City of Portland, Maine - Building or Use Permit Application

Permit No: 03-0900	Issue Date: SEP 25 2003	CBL: 392 X 022001
-----------------------	-----------------------------------	-----------------------------

Location of Construction: 161 Hope Ave <i>City</i>	Owner Name: Volger Theodore J Jr &	Owner Address: 1705 Washington CITY OF PORTLAND	Phone: 97-8800
Business Name:	Contractor Name: Paul Volger Ted Volger	Contractor Address: 1705 Washington Avenue Portland	Phone: 2077978800
Lessee/Buyer's Name	Phone:	Permit Type: Single Family	Zone: R2

Proposed Project Description:
Construct a 30'x40' SF w/10'x22" Breezeway and a 25'x24' Attached 2 Car Garage

Drawing Name: Lot 22 Site and Utility Plan
Project: PRESUMPCOT RIVER PLACE

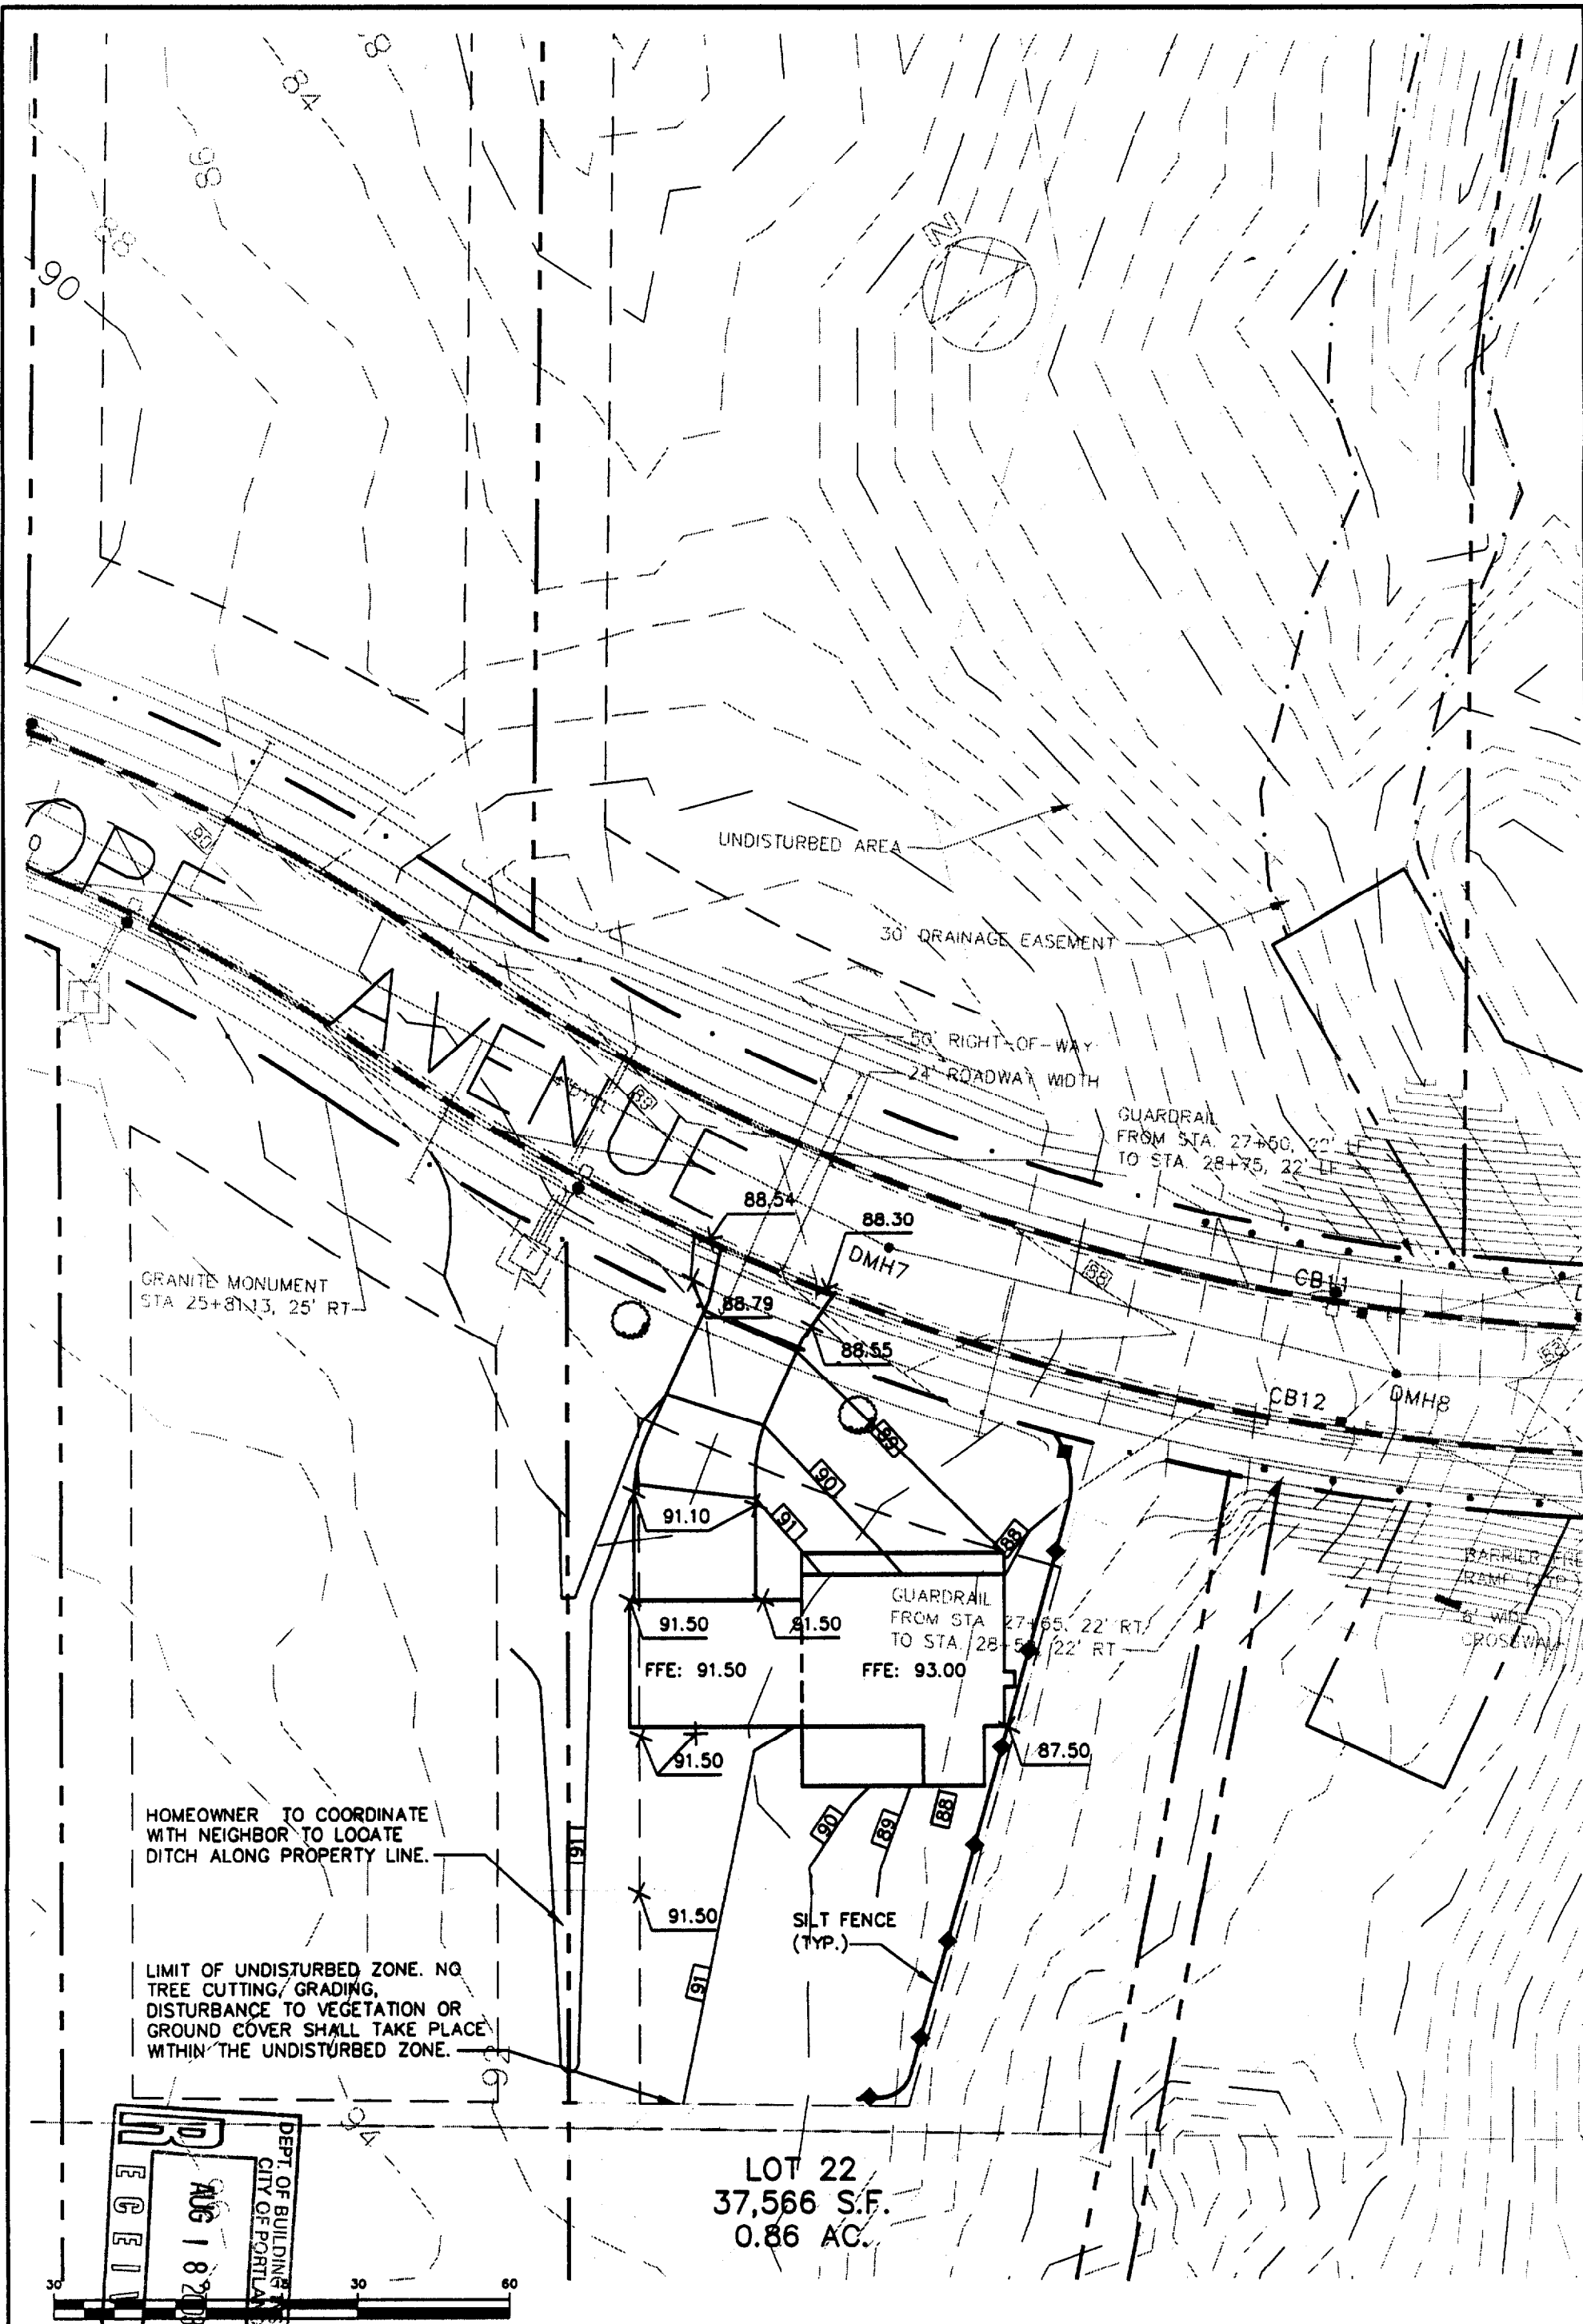
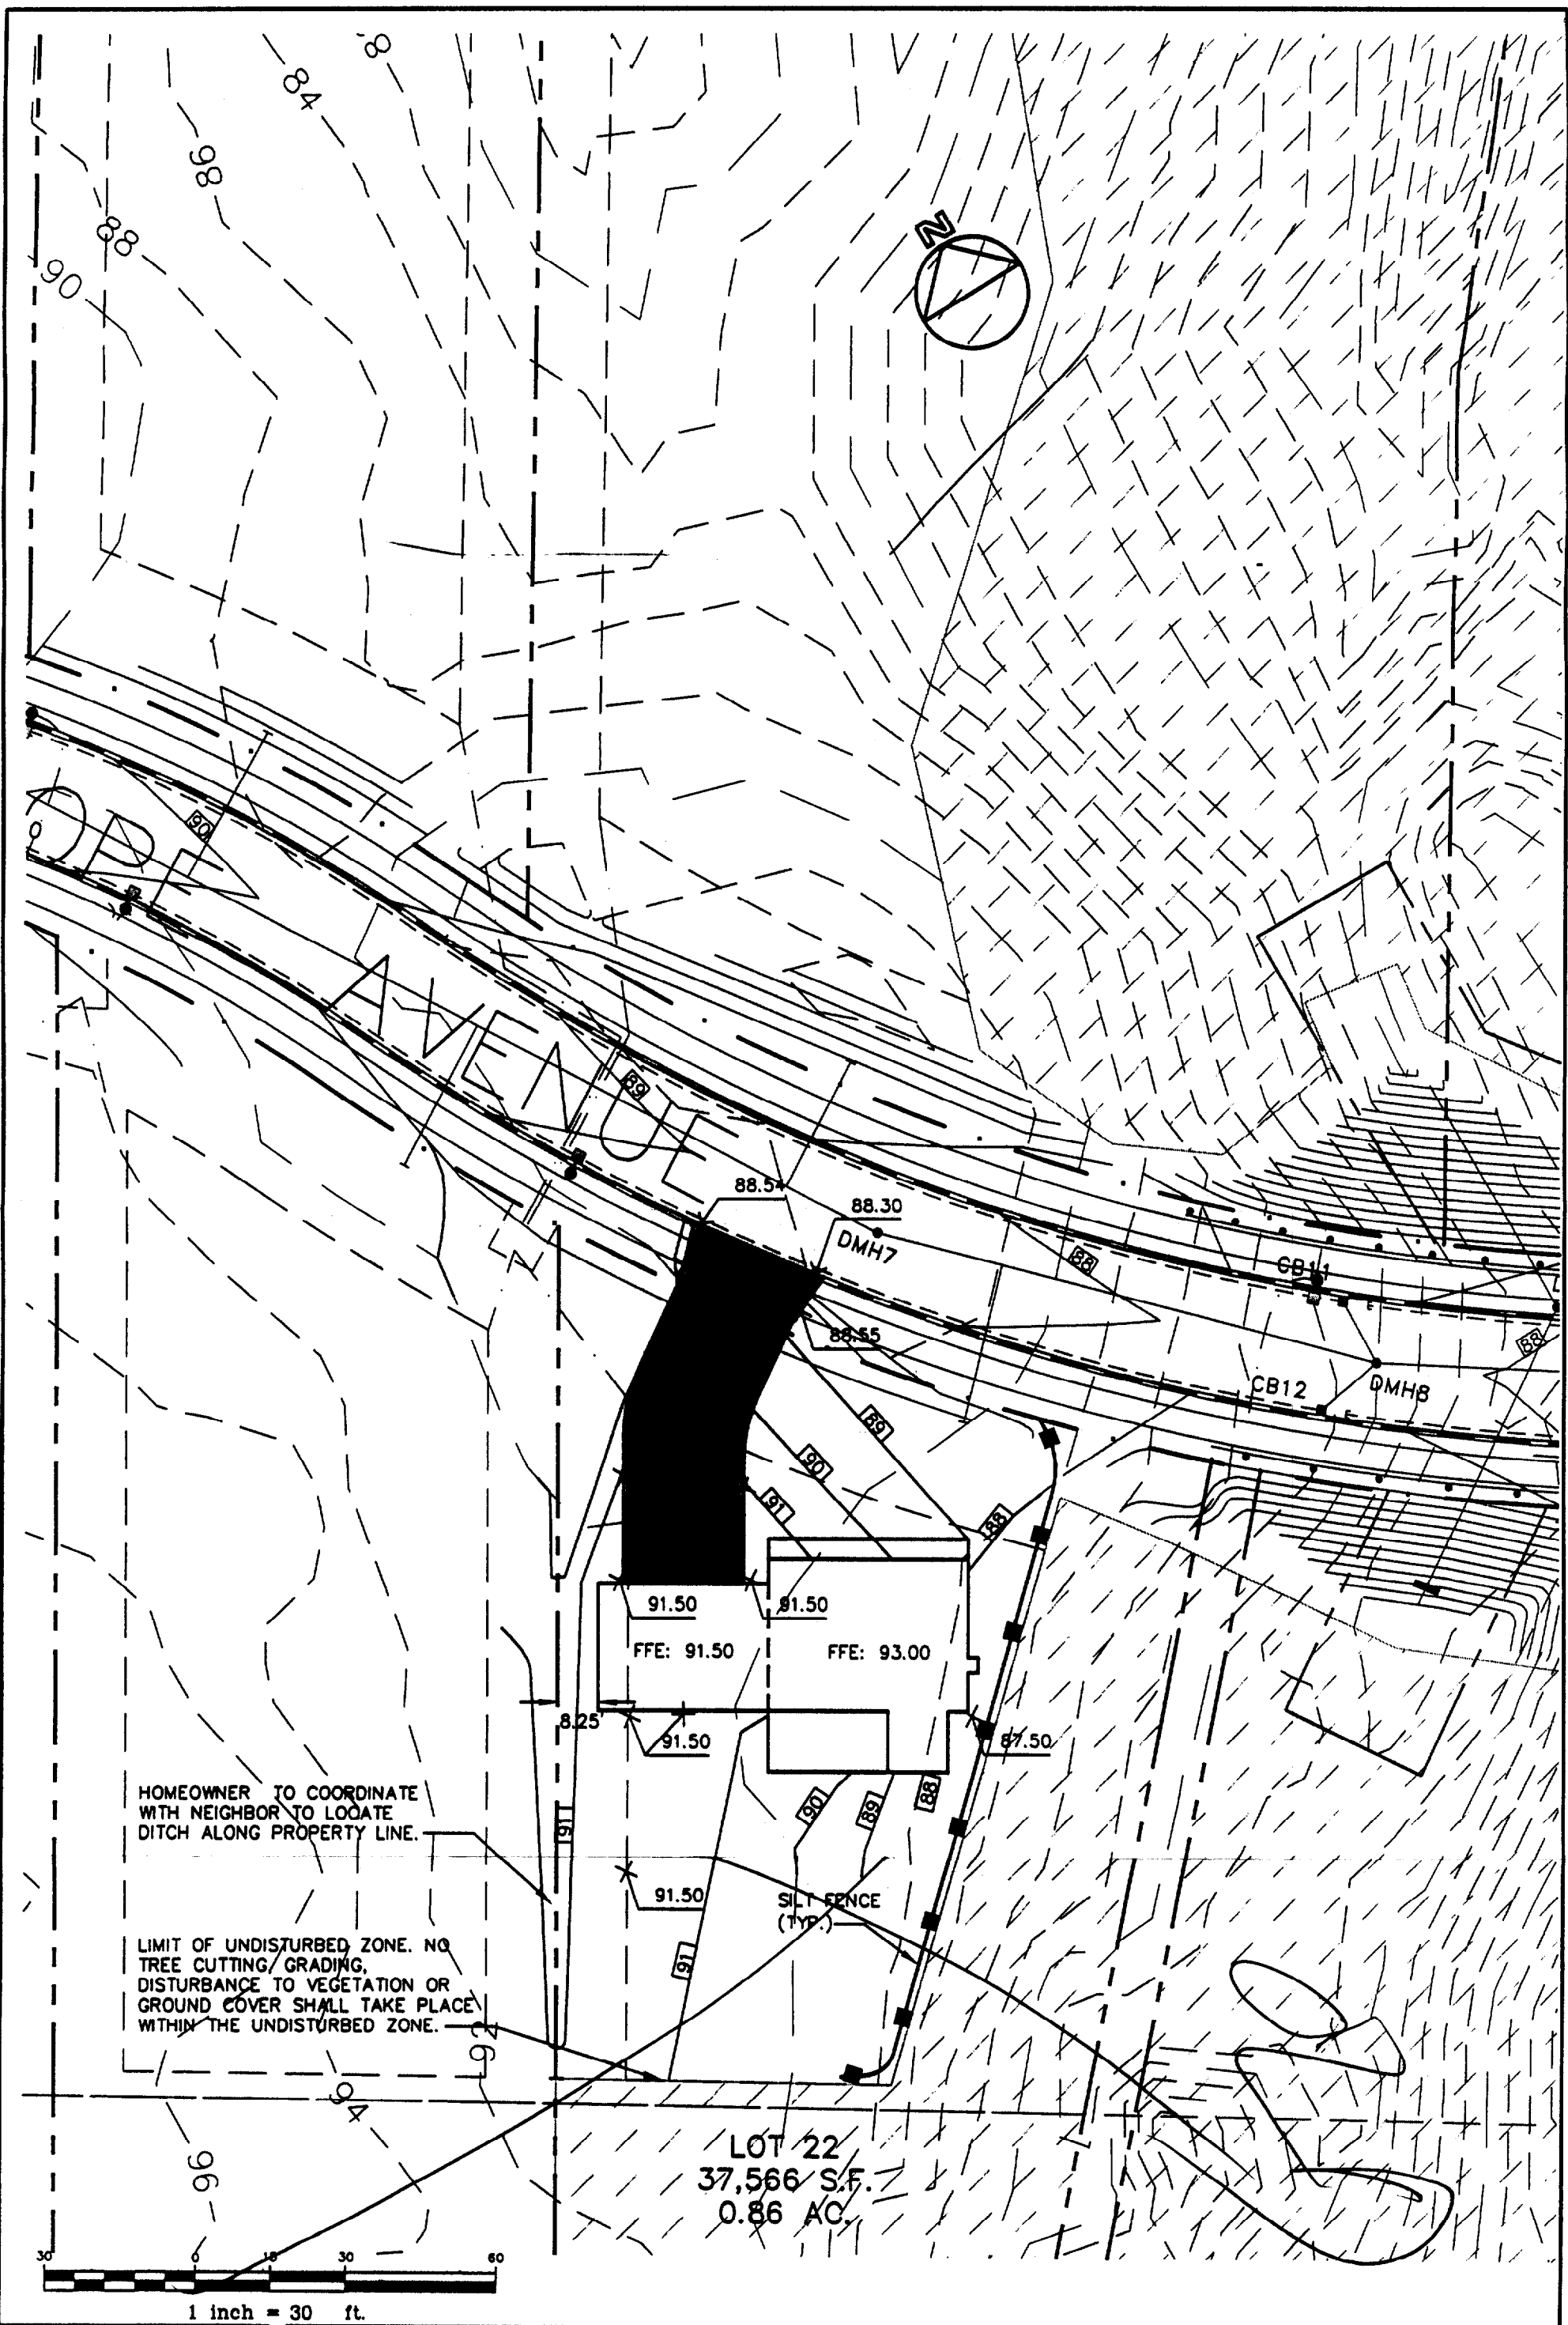
Dept: Zoning **Status:** Approved with Conditions **Reviewer:** Marge Schmuckal **Approval Date:** 08/18/2003**Note:** 08/04/03 No site plan review for this project is in the system - side setback is 8.25 - the R-2 zone does not permit less than 12' - I will write letter 08/18/03 received revised drawings **Ok to Issue:**

Side Yard - 14 ft min with 12' reduction ~~8.25'~~ 30.3' shown NO 8/10/03 new plans 12' 0" min 34.4' shown (12 min permitted)

Your construction plans show a two story dwelling. The R-2 zone requires a fourteen (14) foot side yard setback for a two story dwelling. The required side yard setback may be reduced on one side yard to no more than twelve (12) feet, if for every foot reduced on that one side, it is added to the opposite required side yard. Your plans show one side yard to be eight and one quarter (8.25) feet from the side property line. This is less than the minimum required side yard setback. Please also note that a chimney may not extend more than two (2) feet into a required setback.

Remarks:
 Relocated building to meet 12' side setback

new plans show 12.25' on closest side
